***RE: Grading and Drainage Certification Plan for the Sandia Glow Subdivision (D21/D3B),
Submitted for Release of Financial Guarantees, Engineer's Certification Stamp Dated
4/12/00.***

***RE: Revised Grading and Drainage Plan for the Sandia Glow Subdivision (D21/D3B),
Submitted for Preliminary and Final Plat Approval and Rough Grading Approval,
Engineer's Stamp Dated 1/15/99.***

RE: *Addendum to the Drainage Report for the Sandia Glow Subdivision (D21/D3B)*
Engineer's Stamp Dated 9/21/98.

TITLE: SANDIA GLOW
GRADING AND DRAINAGE DETAILS

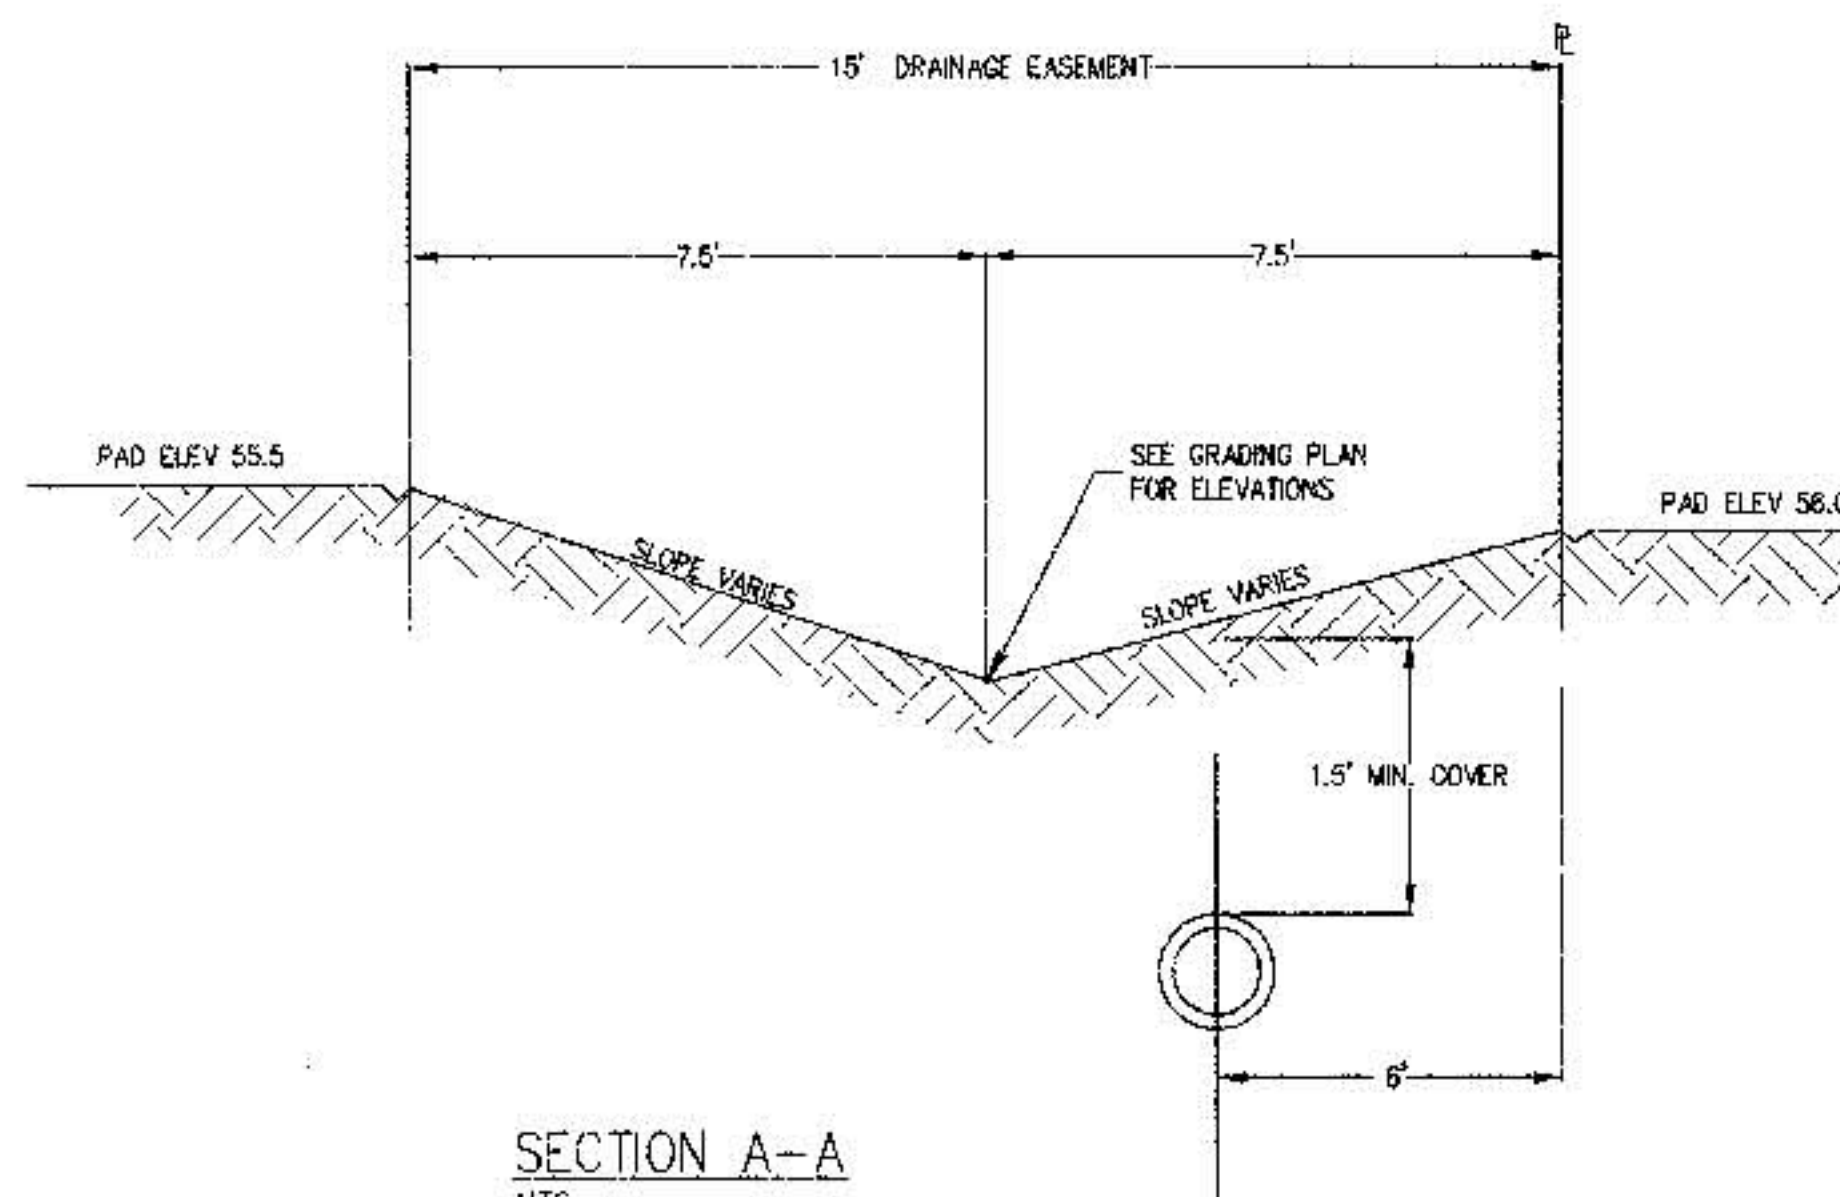
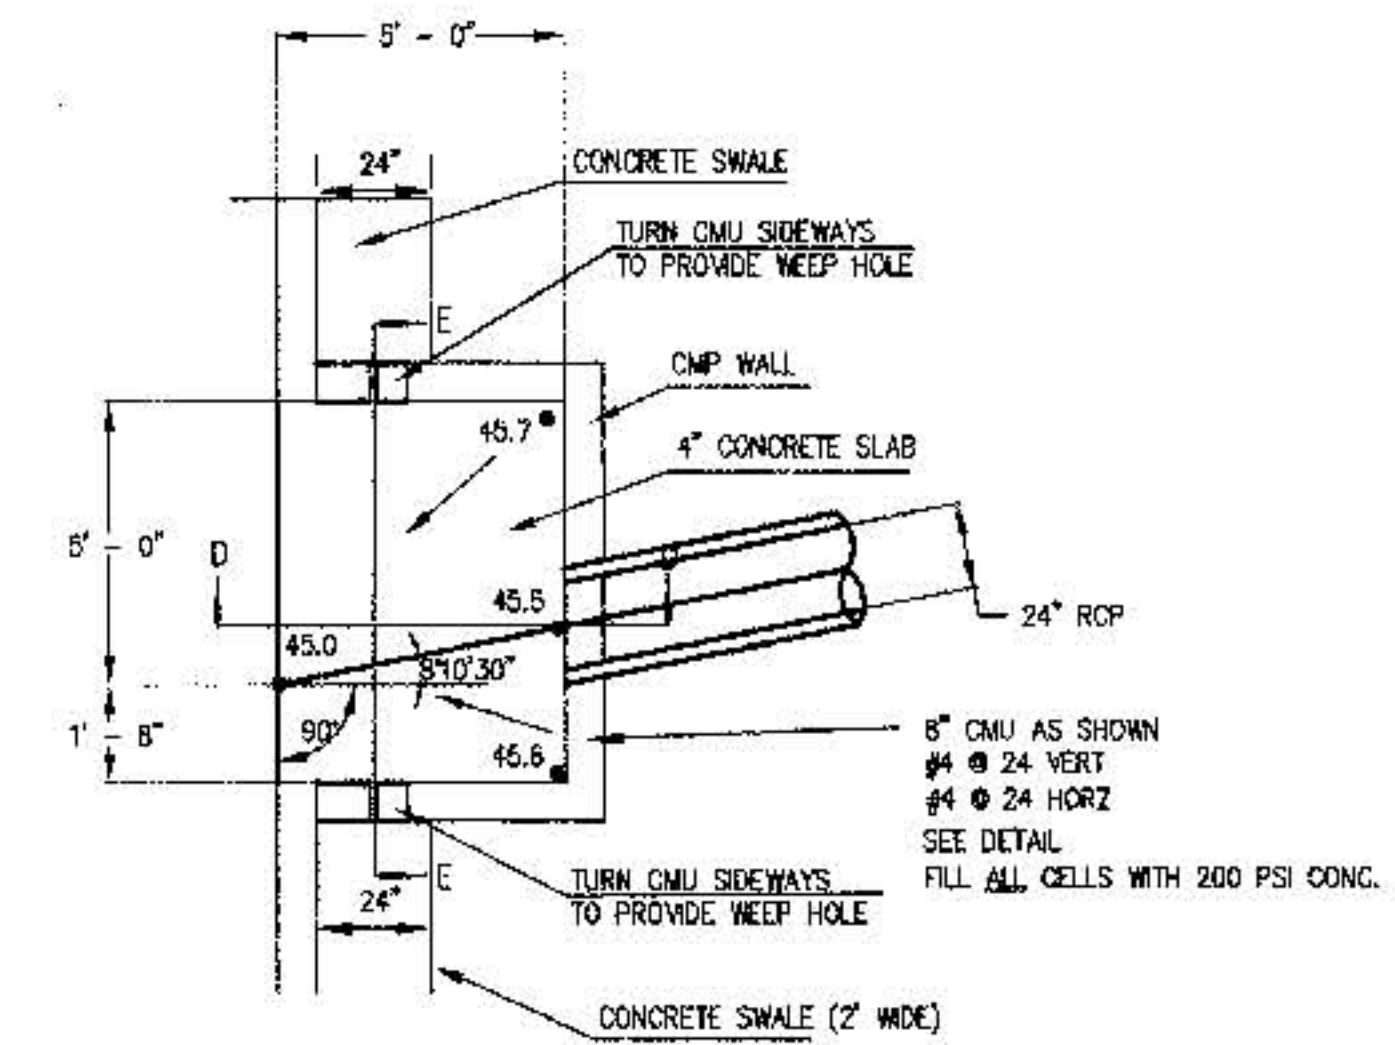
City Hydrology has no objection to your proposal to replace the 10' concrete channel with an underground storm drain pipe. It appears that a revised Infrastructure List will have to be approved by the DRB for this change. Please provide a revised grading plan showing this pipe and the proposed swale prior to DRB approval.

The submittal was unclear whether a 24" or 18" pipe is proposed. Although the 18" pipe has the capacity, using a 24" pipe is recommended for maintenance issues. City Hydrology also recommends that a Type "A" inlet be used instead of the Type "C" inlet. These details may be worked out at DRC.
